Ivanhoe Masterplan Response to Submissions No. 2

Submission	Response
Department of Planning and Environment	
Biodiversity and Trees	
The Arboricultural Impact Assessment (AIA) states all trees identified as being subject to high impact cannot be successfully retained. This includes 164 trees of high retention value and 157 trees of medium retention value. It is however unclear which of these trees form part of the current application and also, which of these trees form part of the Sydney Turpentine Ironbark Forest (STIF). Investigate further potential revisions to the proposed scheme that would allow the retention of additional trees, particularly reducing impacts to those trees forming part of the STIF.	The updated Arboricultural Impact Assessment (AIA) prepared by Ecological (Appendix I) specifies demolition and development impacts separately. Major design changes have reduced impacts on STIF to only three trees at the demolition stage. One tree is identified for removal during the development stage however detailed assessment of this tree can demonstrate retention, as the tree is protected by a retaining wall that will not be removed.

DA01.MP.100[8]

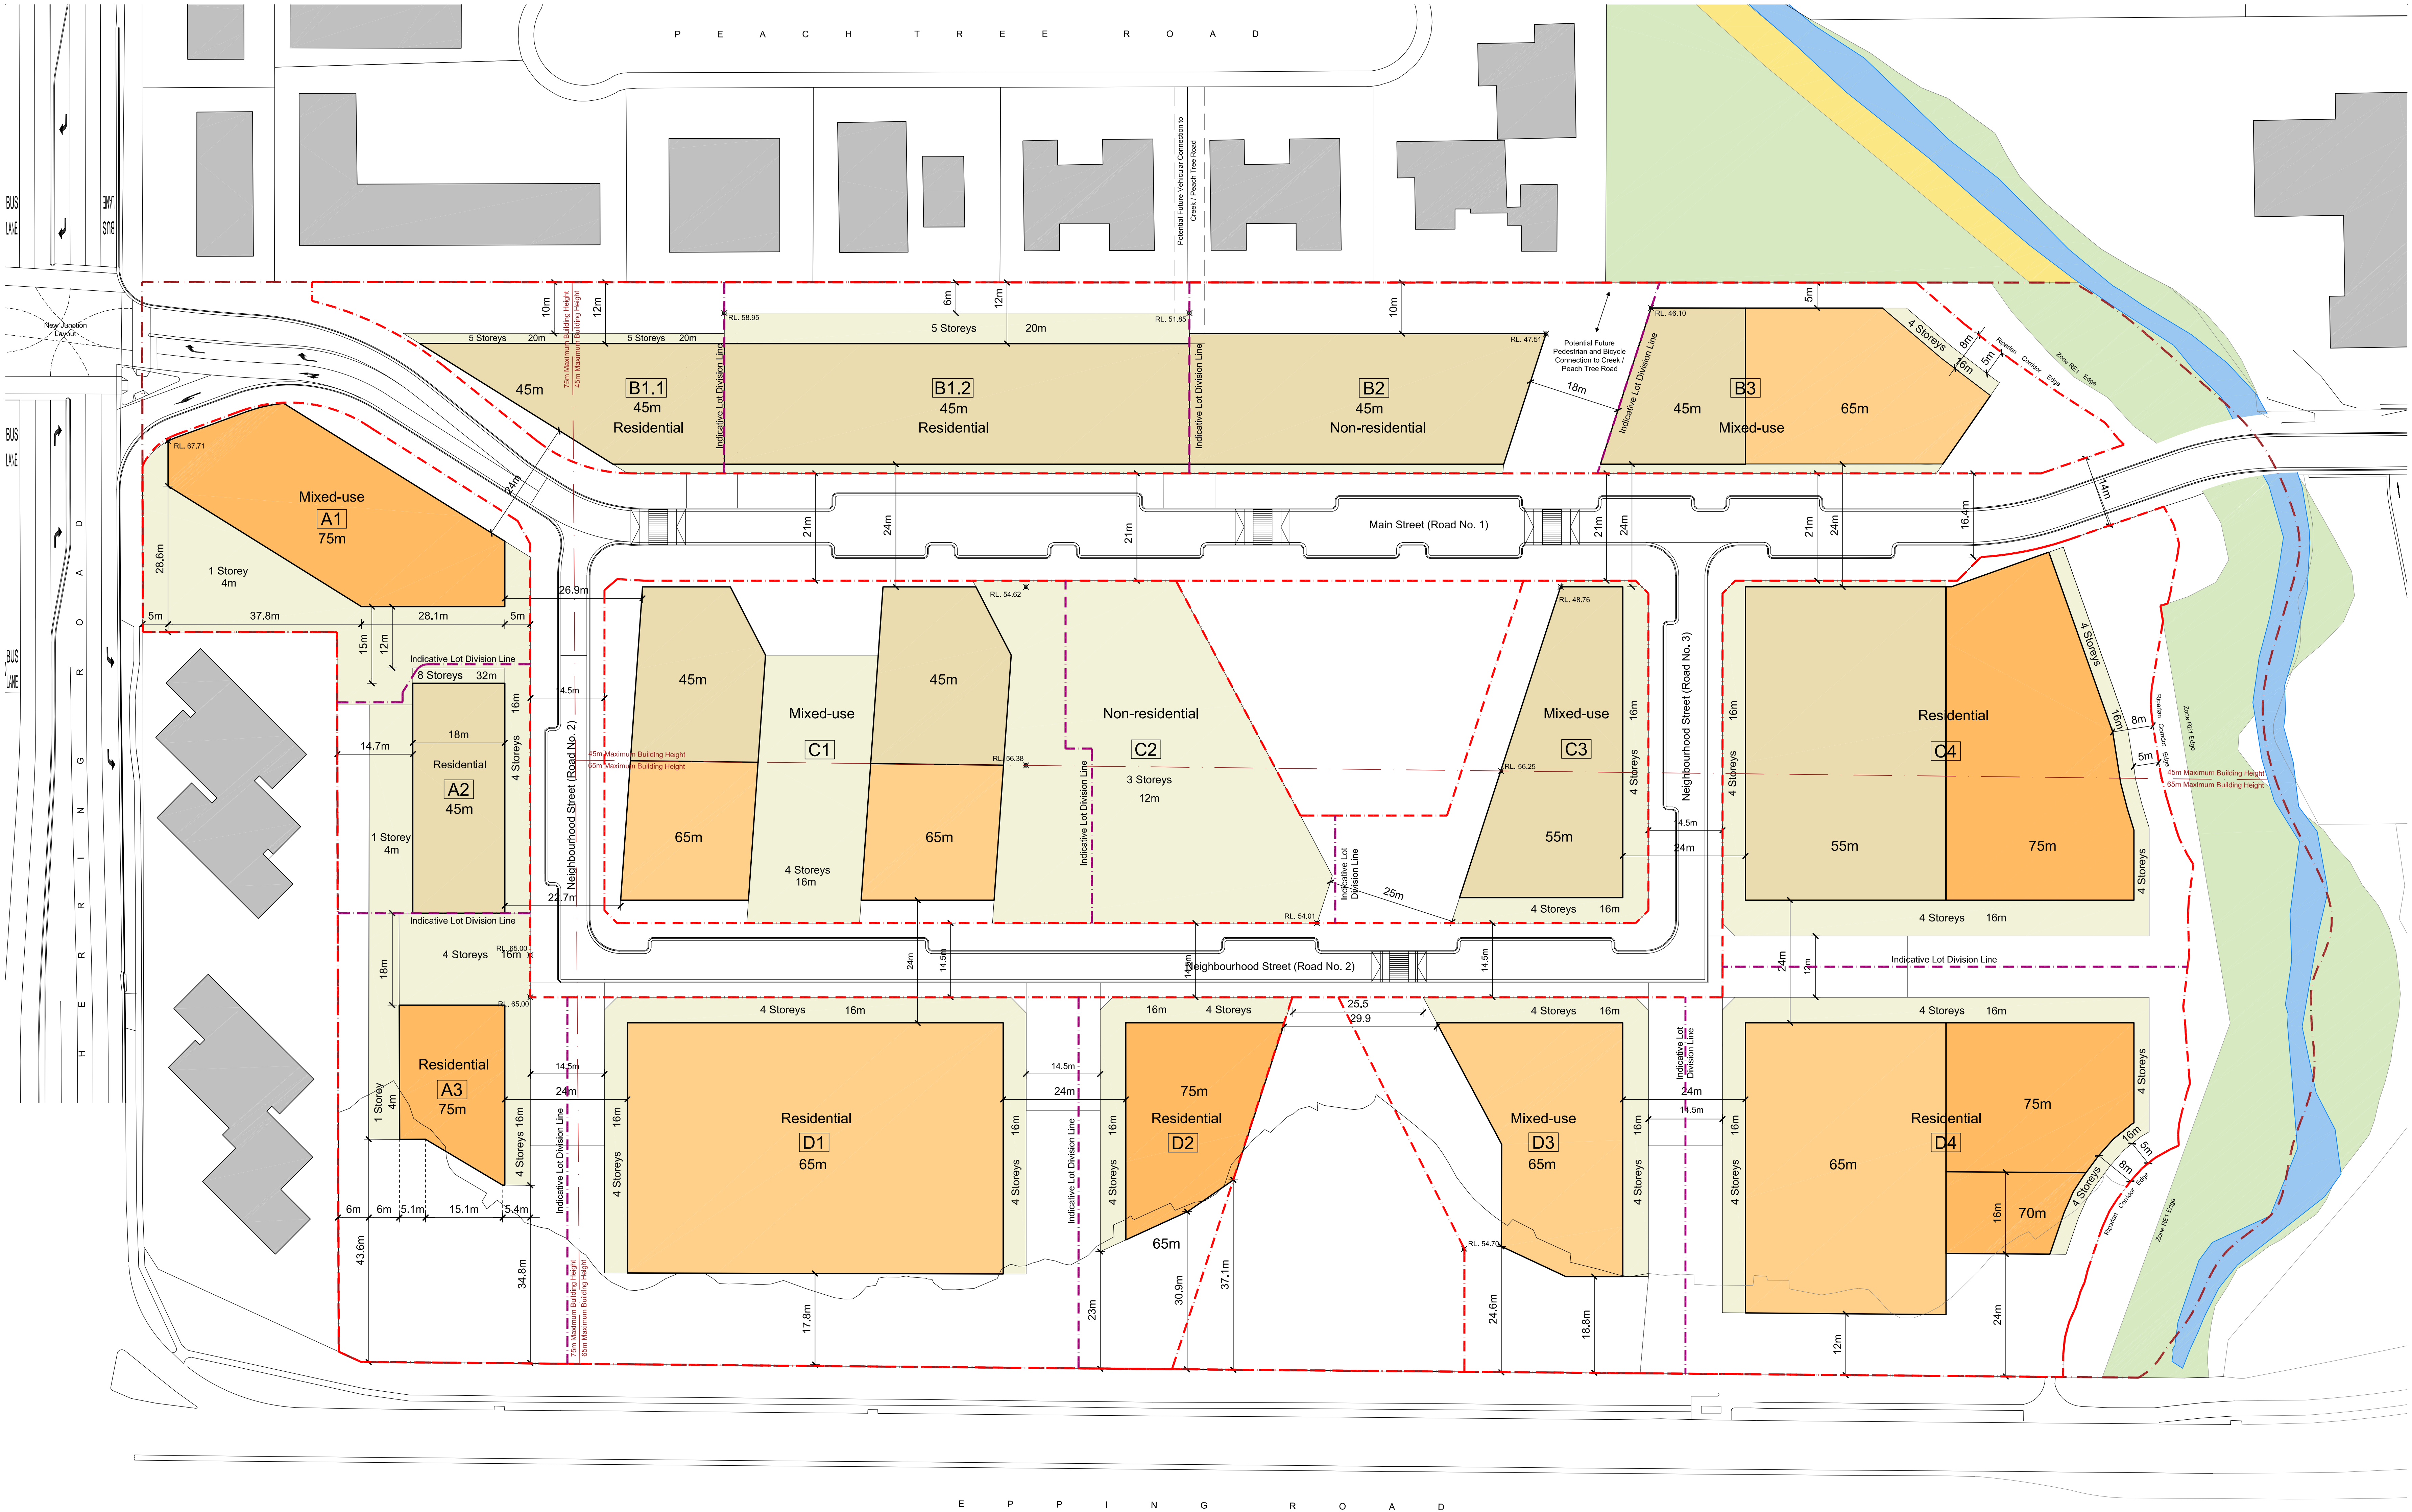
Given the indicative height/scale of the proposed community centre, review the proposed 3 storey/12 m building height on drawing DA01.MP.100(7).	Aspire have been collaborating with City of Ryde for over 18 months on a VPA for Ivanhoe. This includes, amongst other items, a community centre and public swimming pool. Up until this submission, there has not been any brief or conclusive information of Council's requirements. The envelope was left flexible to accommodate this process.
Provide a schedule of the different types and sizes of the proposed open spaces (i.e. useable public open space, private communal open space, the Shrimptons Creek riparian zone, deep soil zones). Please also include a breakdown of the areas of the Village Green, Forest Playground, School Garden and Forest Threshold parks.	Revised open space areas shown on drawing DA02.MP.202[6B].
Respond to Council's comments regarding the proposed quantum of community space, deletion of the swimming pool and the relocation of the proposed community centre above ground level.	A detailed response to Council's submission is provided at Appendix C .

Submission	Response
Clarify/illustrate where the one-storey elements of buildings A1, A2 and A3, as shown on drawing DA01.MP.100(7), are located underground, the future soil depth above these areas and the ability of these areas to sustain deep soil planting. Also provide a setback dimension on drawing DA01.MP.100(7) between these elements and the site boundary.	Envelope Plan DA01.MP.100[8] in Appendix D illustrates the location of the one-storey elements. The one storey elements on A1, A2 and A3 are to allow re-levelling of the landscape and single storey structures above the basement without breaching envelope controls. Deep soil is not proposed in these areas. Basement plan DA02.MPB02[6] in Appendix D has been revised to show a deep soil for 6m alongside boundary.
Review drawing DA01.MP.100(7) to ensure consistency with the Building A1 and Building C1 site boundaries contained in SSD 8903.	Updated subdivision plans are provided in the Stage 1 Response to Submissions, which are aligned with the detailed application for Buildings C1 and A1.
